OXFORDSHIRE COUNTY COUNCIL'S RESPONSE TO CONSULTATION ON THE FOLLOWING DEVELOPMENT PROPOSAL

Application no: 14/02004/HYBRID-2

Proposal: AMENDMENT: Outline planning application (all matters reserved except for means of access) for a mixed use development comprising: up to 1,200 dwellings, including affordable housing and up to 120 unit care village (C2) with associated publically accessible ancillary facilities; site for a new primary school; up to 930sqm of retail space; up to 13,800sqm of locally led employment (B1/B2/B8) including transport interchange; site for a Football Association step 5 football facility with publically accessible ancillary facilities; public open space; associated infrastructure, engineering and ancillary works.

Location: Land South Of Perdiswell Farm Shipton Road Shipton On Cherwell

Movement and Access Parameter

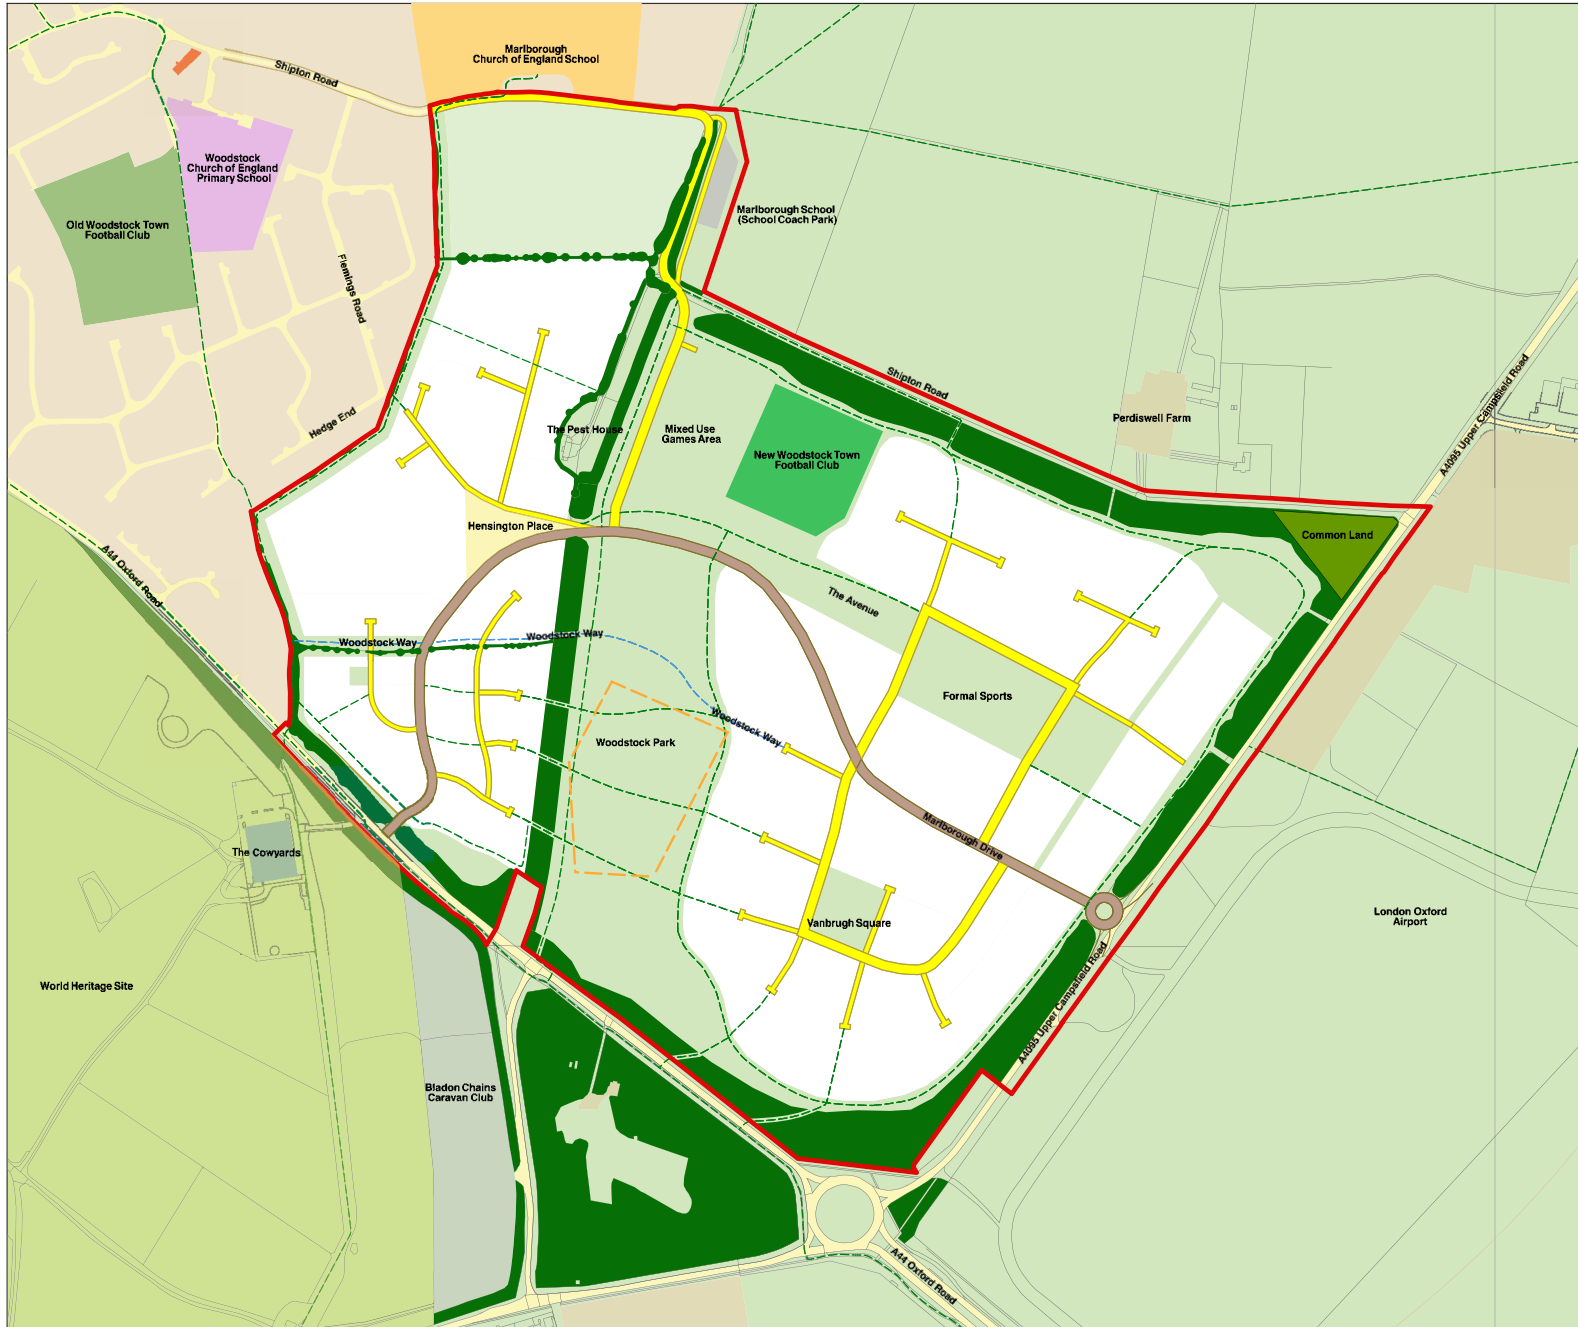
- The transport interchange (formerly Link & Ride) car park is contrary to transport strategy as set out in the Oxford Transport Strategy that forms part of the emerging Oxfordshire County Council Local Transport Plan 4, 2015 – 2031.

Property Services have raised an objection on the basis that the school site layout design guidance provided has not been followed. For example the school site is shown to be on a dead end and is inadequately connected to the street network.

However, Oxfordshire County Council objects to the revised proposals for the Woodstock East development on the grounds that the 300 space transport interchange (formerly Link & Ride) car park does not fit with the long term strategy for Park & Ride on the A4260 and A44 corridors as set out in its emerging Local Transport Plan 4 (LTP4).
